From: Anita Gardner <Anita.Gardner@arun.gov.uk>
Sent: 29 January 2021 19:45
To: Planning.Responses <Planning.Responses@arun.gov.uk>
Subject: FW: FG/123/20/PL - Land at former McIntyre Nursery

Re: Standby Self Storage: Land at former McIntyre Nursery - FG/123/20/PL

STATUS	CLIENT		
Outline Design	Standby Self-Storage		
SCALES	DATE	SIZE	
1 : 200	Sept 2020	A2	
TITLE			
PROPOSED SITE & BLOCK PLAN			
DWG NO			REV
5320-2		d

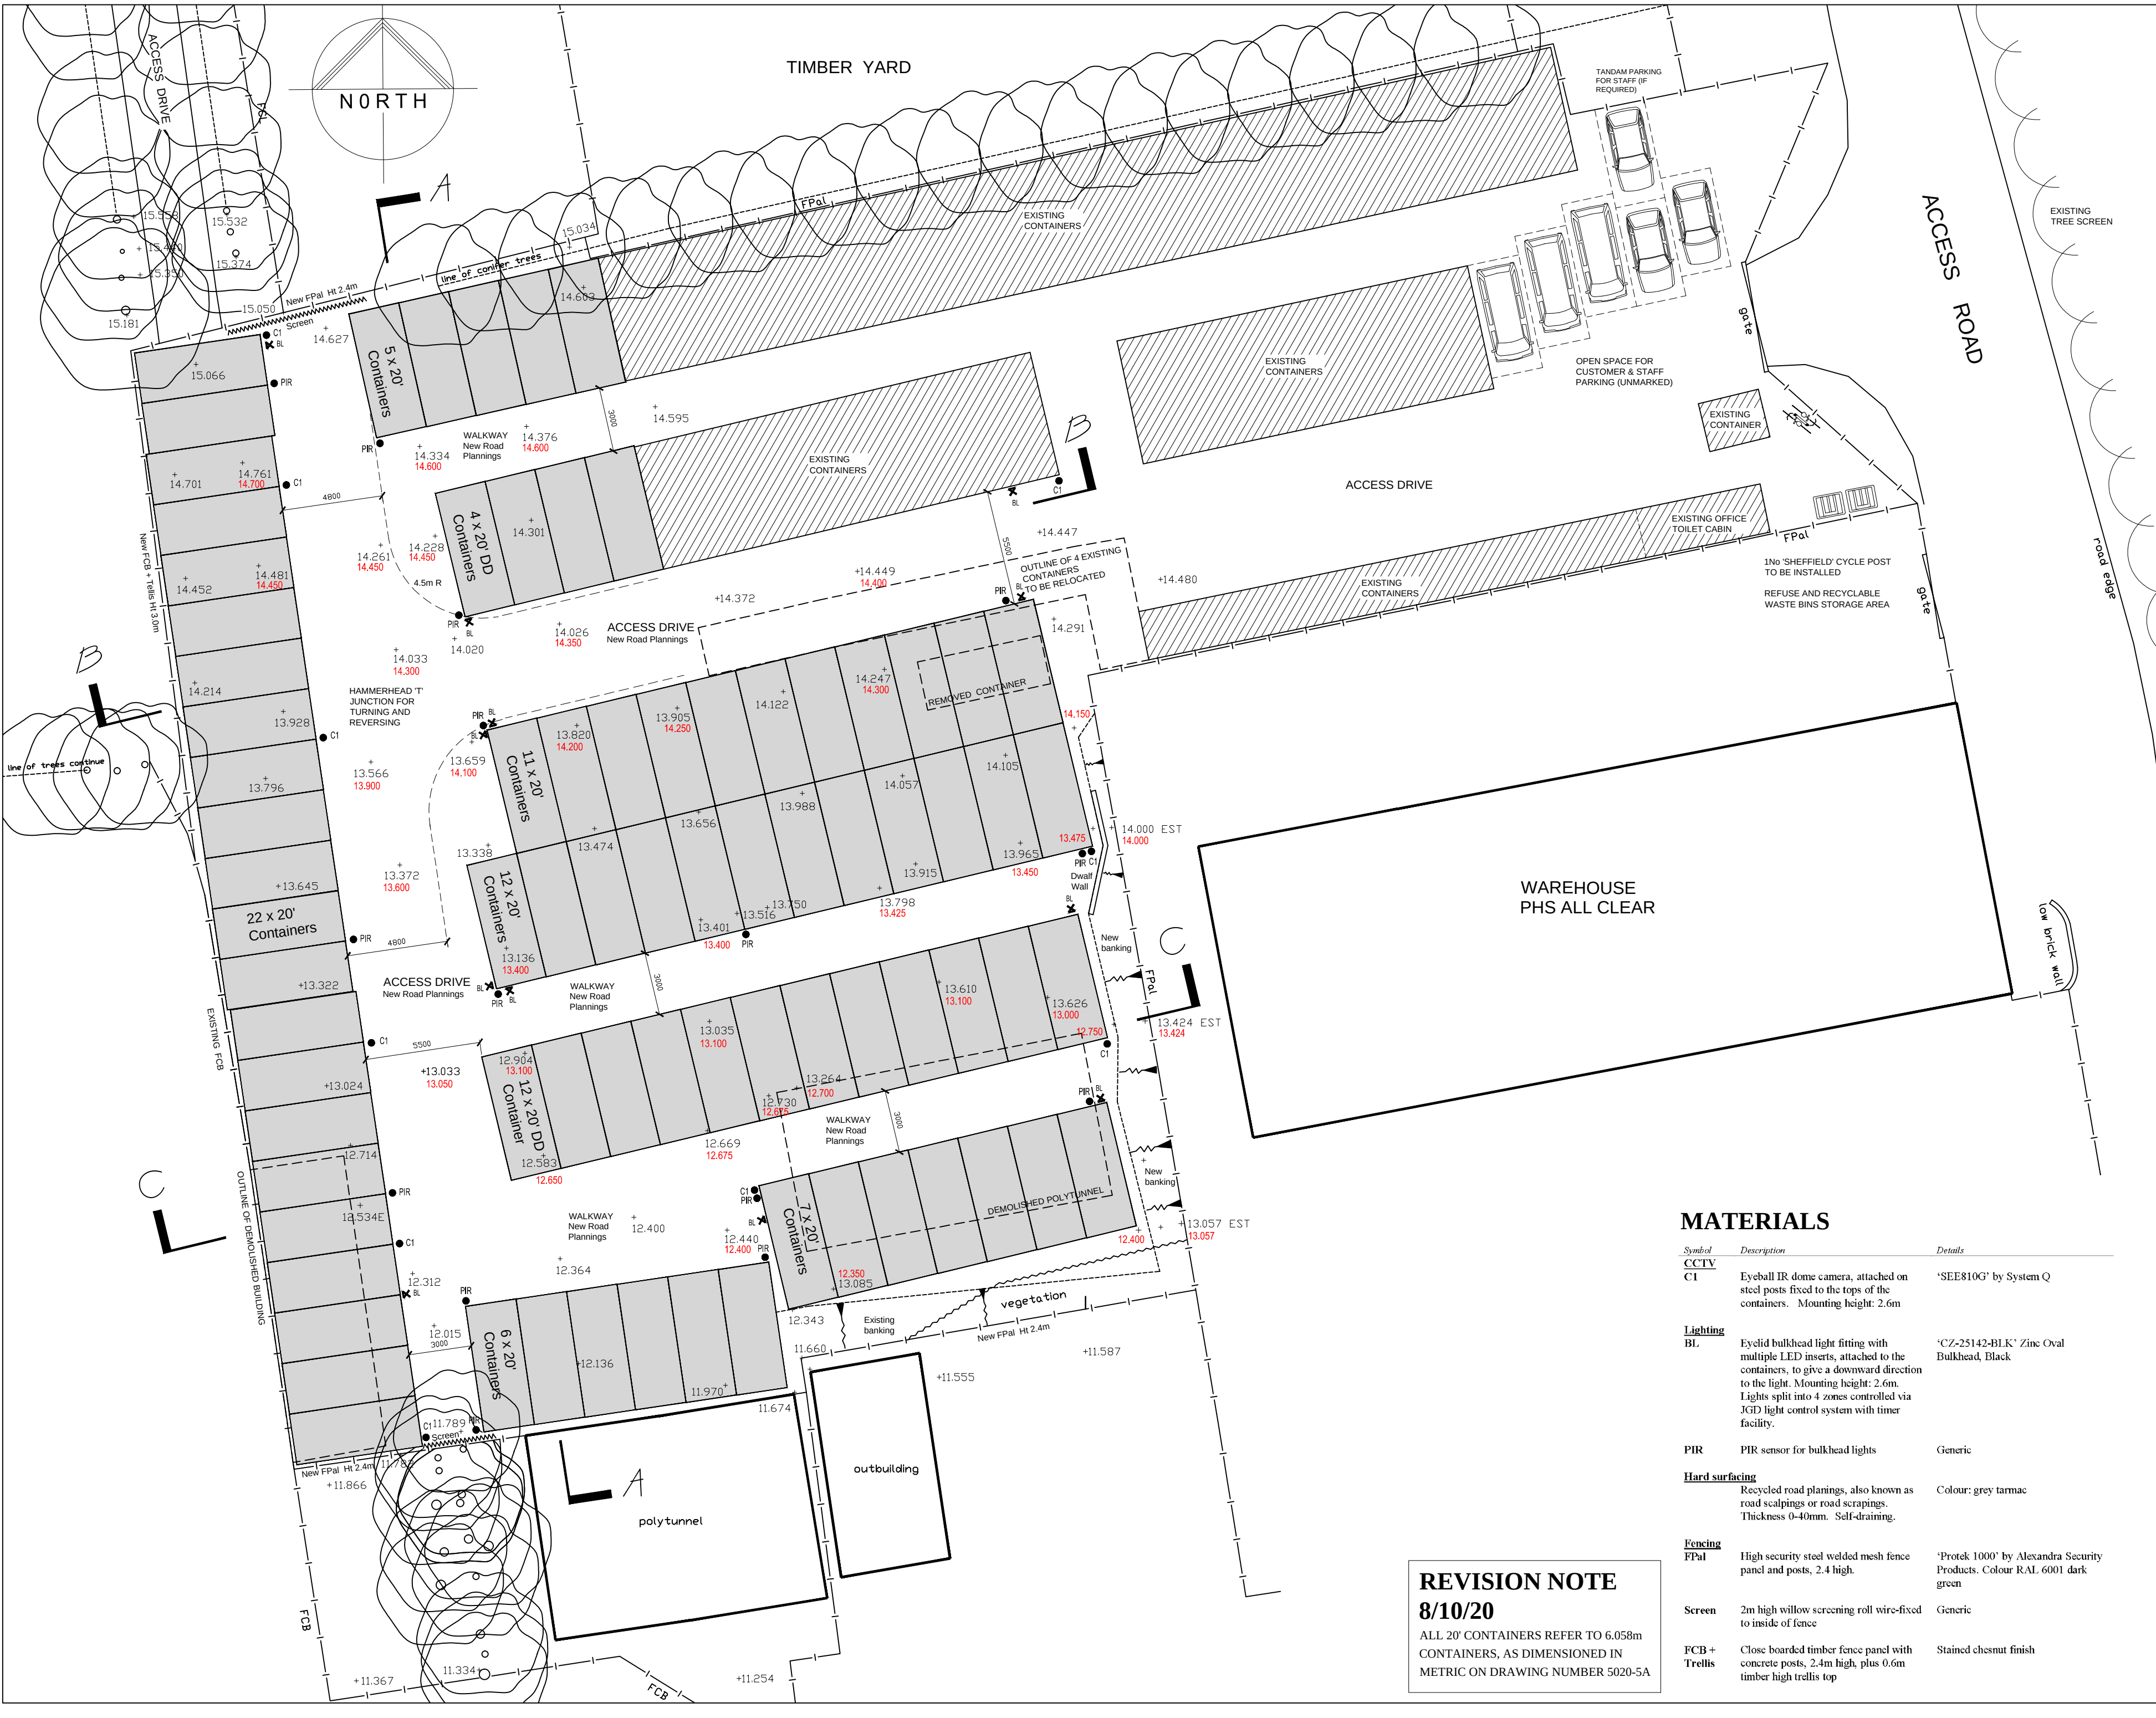
Dear John,
I have a query regarding car parking.
The design and access statement states :
'Two additional parking spaces are proposed in the existing parking area to provide 6 spaces for the combined site. This is considered sufficient as demand for on-site parking is limited due to the nature of the proposed self-storage.'
The County Highway officer requested imposition of the following condition:
Car parking space (details required)
'No part of the development shall be first occupied until the car parking spaces have been constructed in accordance with plans and details to be submitted to and approved in writing by the Local Planning Authority. These spaces shall thereafter be retained at all times for their designated use.'
Reason: To provide car-parking space for the use.'
You have provided the response below. However, in order to provide this additional parking it looks from comparison of the site plans that an additional space is being provided at the site entrance in the area of the grass verge so it would seem that this condition is necessary.

On this basis please can you let me know why you consider imposition of this condition would not be reasonable/
Regards
Anita Gardner

Subsequent to the completion of the report, a revised lighting scheme and amended proposed site plan was produced to address a concern about a possible impact on surrounding land and its potential habitat for bats. These revised proposals have been reviewed by the ecologist in a reporting letter dated 29th December and assessed as acceptable. I attach these 3 additional documents.

3. External Lighting: a detailed lighting scheme was submitted with the application, but appears not to have been noted or commented upon. As mentioned previously, this scheme has now been revised and reviewed by an independent ecologist. Is this acceptable?

Upon reviewing the matter again I do appreciate, as you say, the extra car parking space coincides with the location of a grass verge next to the entrance gates, as shown on the 2018 proposed plan for Standby Storage's existing site. On that basis, I therefore agree that the suggested condition might then be appropriate. On the other hand, the CHA did not advise such a condition was necessary in 2018 when consent was granted to lay hard surfacing for the 5 adjacent parking spaces!

2. Details of Car Parking Spaces: the hard surfacing on the adjoining site already exists. There is therefore no proposal to construct or formally set out additional car parking on the application site. The proposed plans of the amalgamated site simply illustrate that at least 6 car and van spaces can be spatially accommodated near the entrance gate. The dashed lines show the parking spaces 2.4 wide x 4.8 or 5.5m long. There is further space within the development site for additional informal parking, as acknowledged by the CHA.
